Consultation Response from KC, Highways Development Management
2023/93759 12, George Street, Ravensthorpe, Dewsbury, WF13 3LL
Change of use from storage to garage, erection of single storey side extension and formation of vehicular access
Date Responded: 05/03/2024. Responding Officer: D. Stainsby Responding Ref: K14-4SW/1

This application is for a change of use from storage to garage, erection of single storey side extension and formation of vehicular access at 12, George Street, Ravensthorpe, Dewsbury, WF13 3LL.

DRAWING No
A1-CAD/01
REVISION /

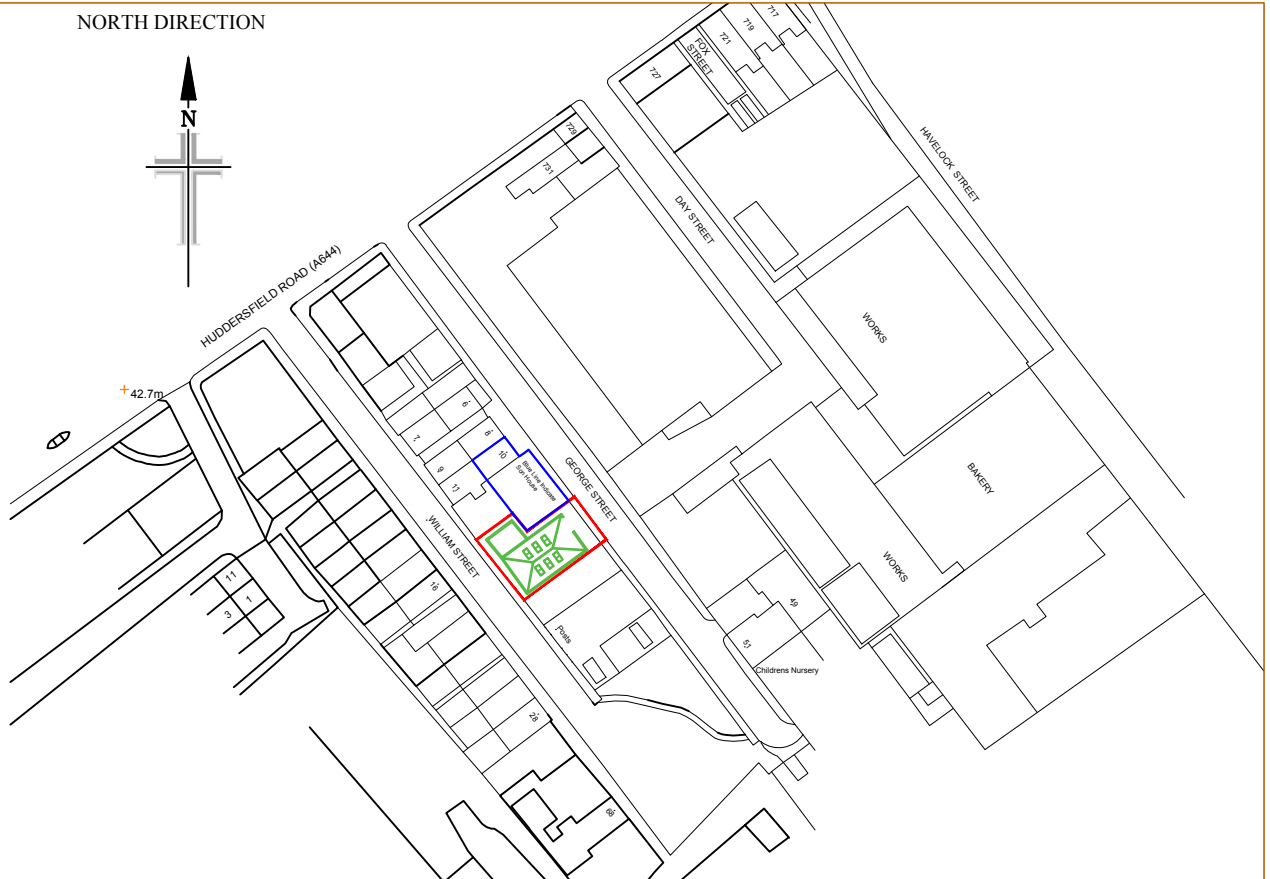
- A revised plan showing that the whole site is located within the red line boundary needs to be provided.
- A revised plan showing the replacement parking for No 11 George Street needs to be provided.
- A revised plan showing a suitable waste/storage area on the site together with a bin storage area for No 11 George Street needs to be provided.
- A revised plan showing the dropped kerb extending across the whole of the site frontage needs to be provided.

The parking/yard area is proposed within the neighbouring land owned by No 11 George Street and the red line boundary will need to be extended to incorporate this area into the application site.

The plan shows a further area to the south of the site to be used for parking. However, again this area is not within the red line boundary of the site and does not appear to be in the ownership of the applicant. Therefore, this area cannot be counted as potential parking for the proposals.

DRAWING STATUS FOR APPROVAL		DRAWING No A1-CAD/02D	
DRAWN	MAMJID	DATE	24/03/2025
SCALE	1:100 @ A1	REVISION	D

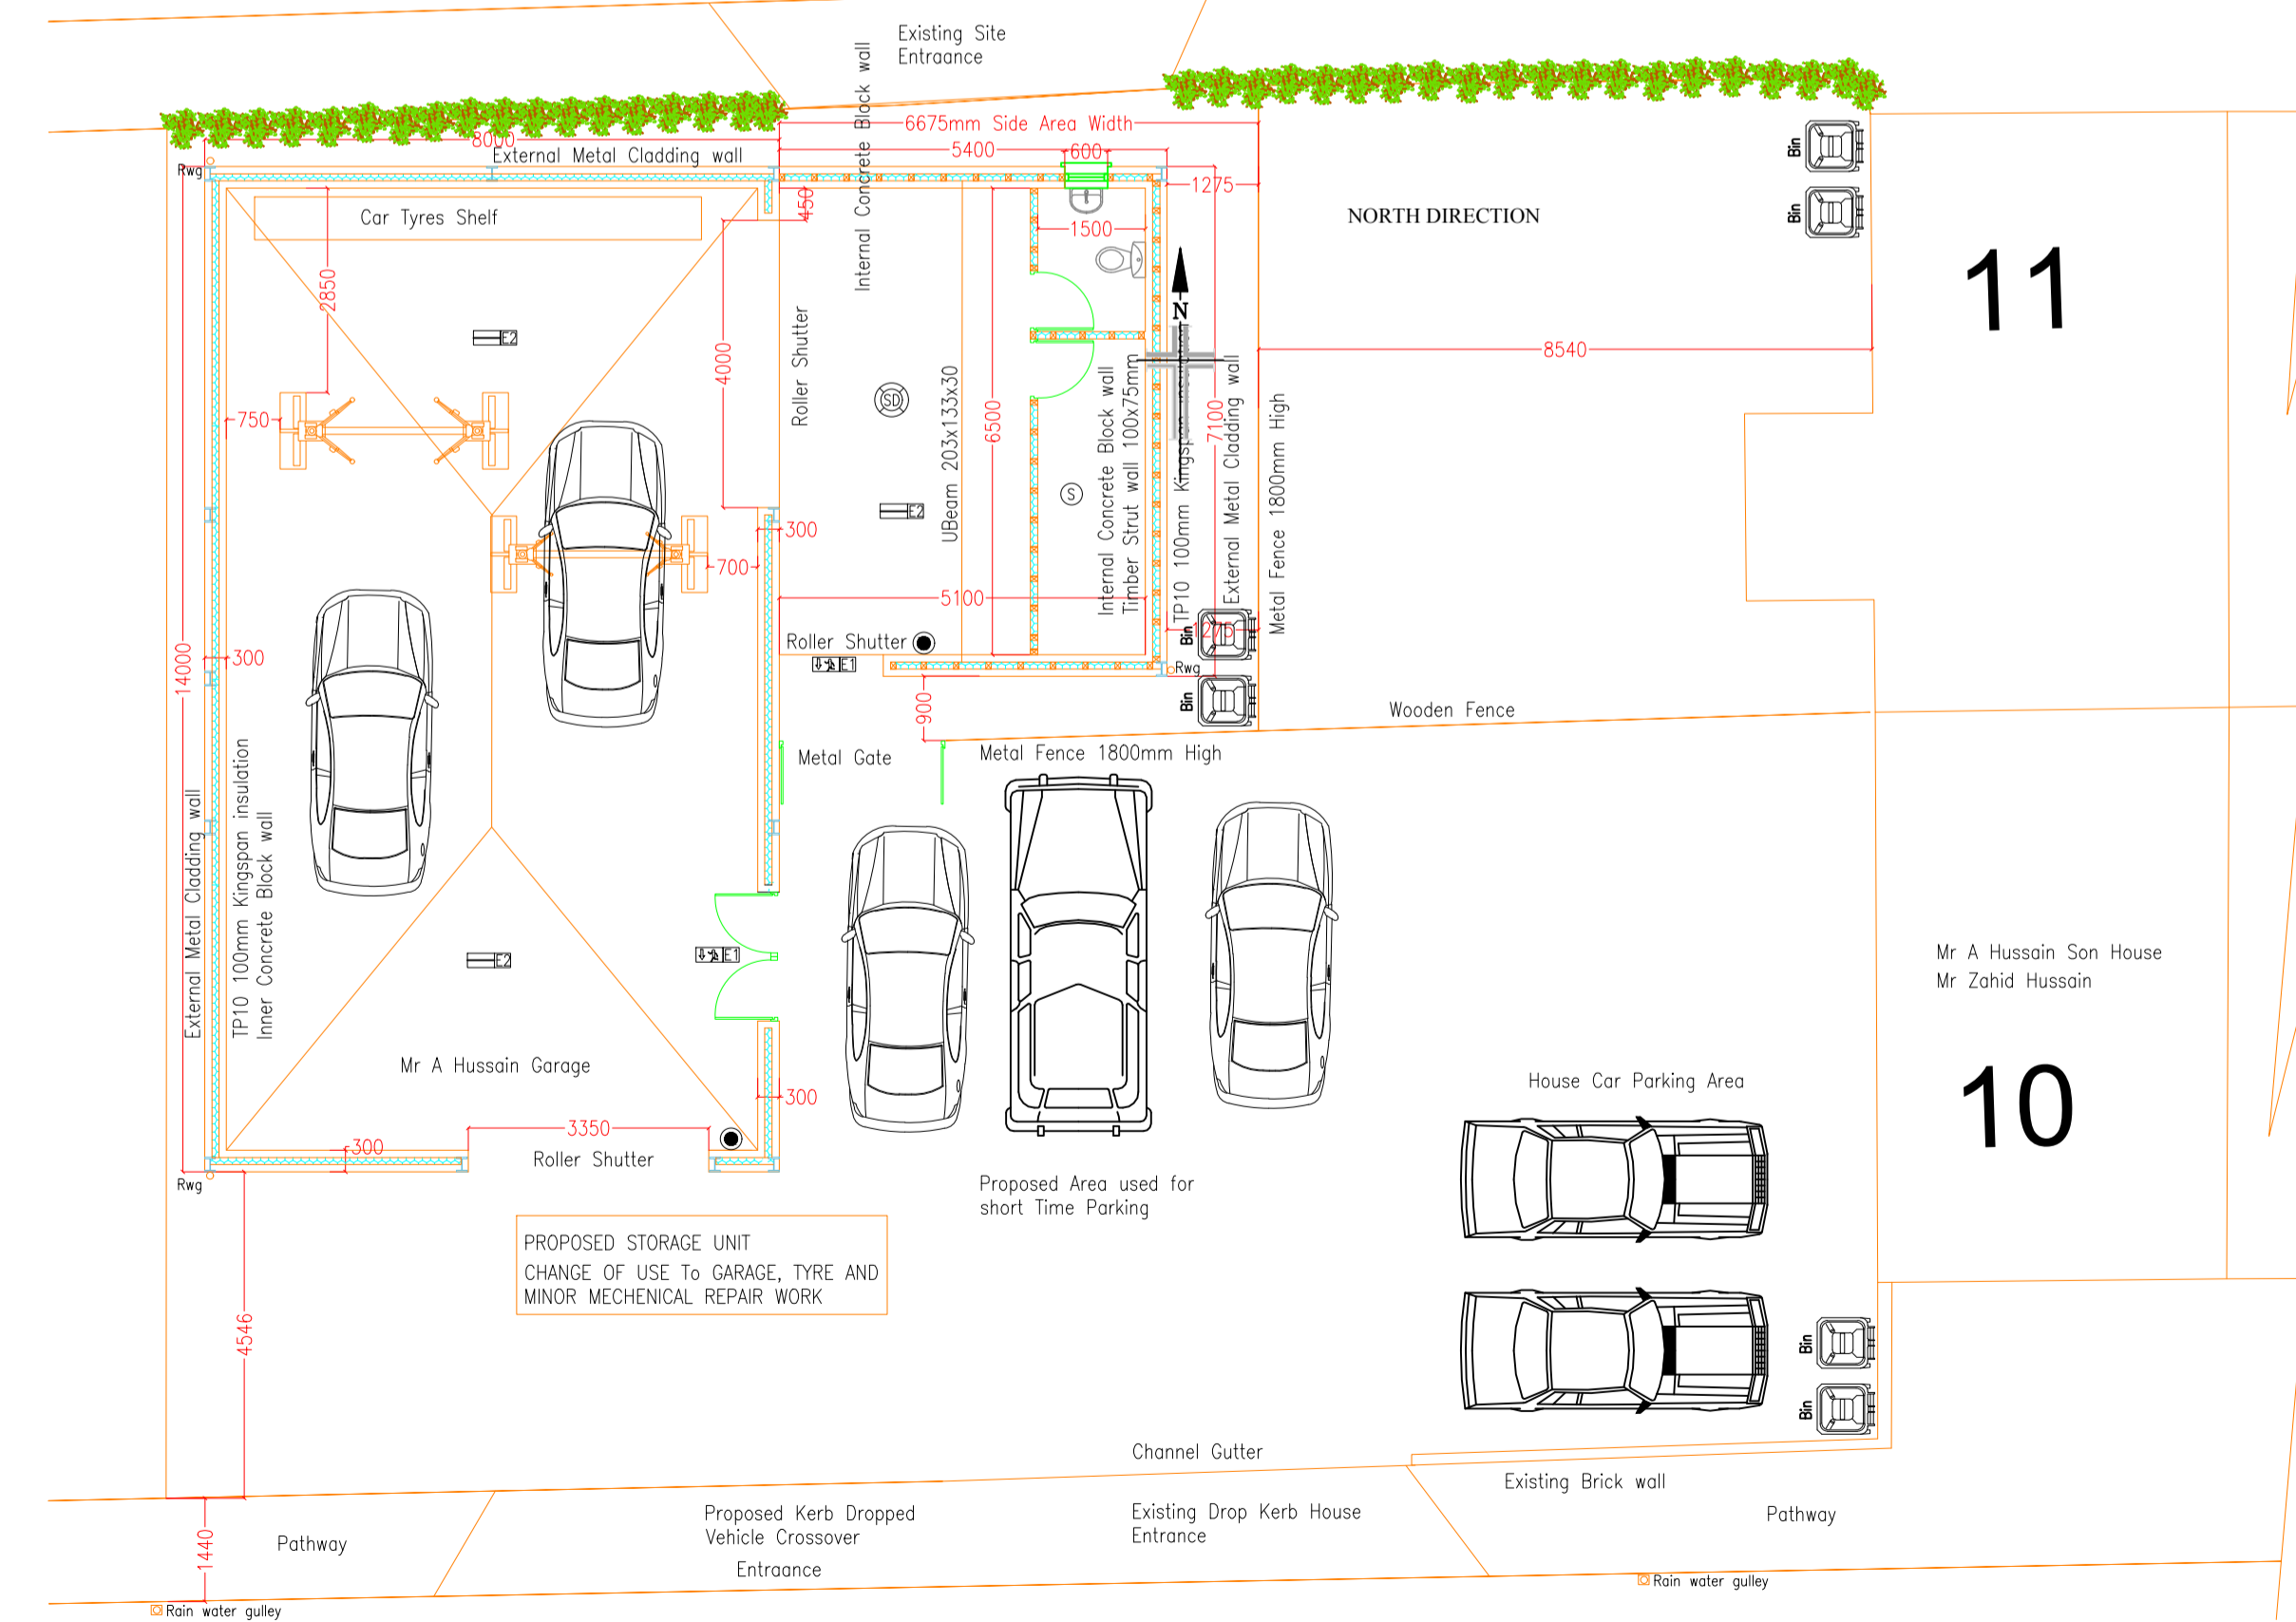
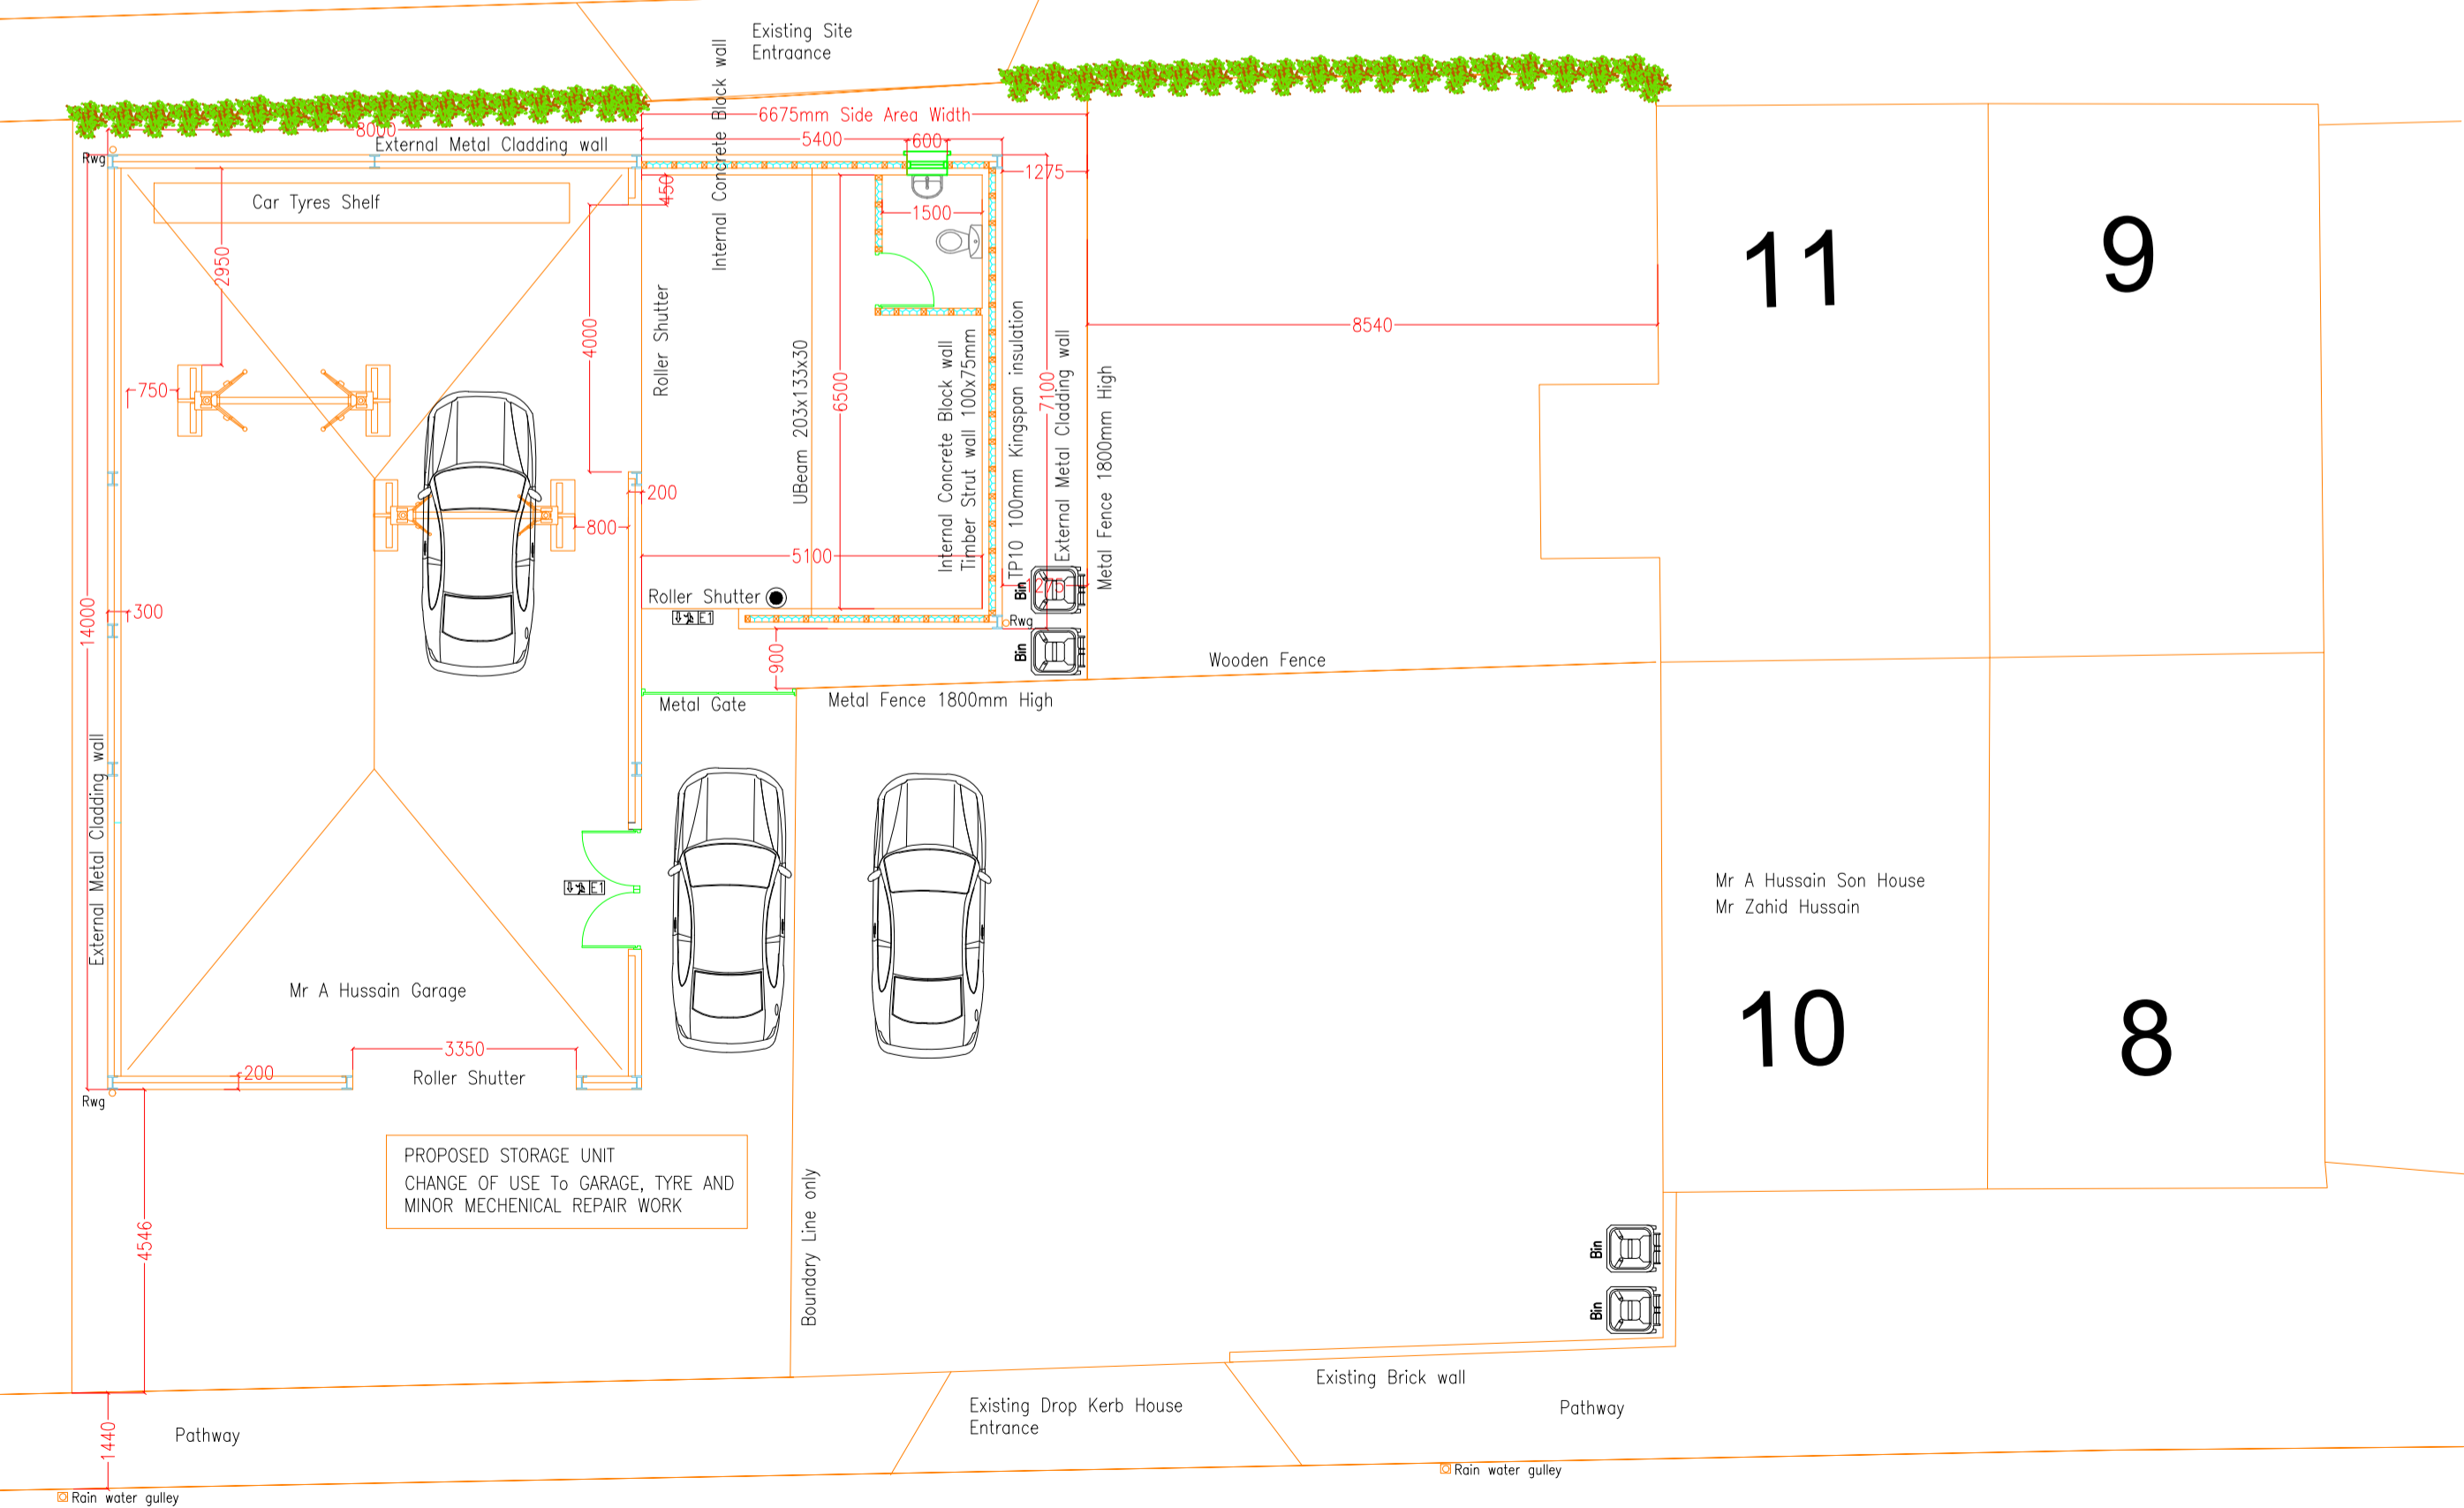
A new vehicle access is proposed from George Street. But this does not provide vehicle access to the proposed parking area on the site frontage on George Street.

A revised plan showing the dropped kerb extending across the whole of the site frontage needs to be provided.

Currently No 11 George Street has off street parking which will be removed by this application. No alternative provision is proposed to replace the loss of this off-street parking. This parking will need to be provided elsewhere on the application site.

The parking area on the site forecourt fronting onto George Street is too small to accommodate any vehicles without them overhanging the public footway and causing an obstruction to pedestrians.

The depth of the forecourt will need to be extended to a minimum of 5.0m from the back of the adopted footway into the site for this area to be able to accommodate parking safely.

The proposed plan shows two typical residential waste bins on the site.

Bearing in mind that the proposed use is for a garage and tyre repair centre the waste/storage area will need to be increased substantially and the proposed size and location demonstrated on a plan.

A separate bin storage area will need to be provided for No 11 George Street
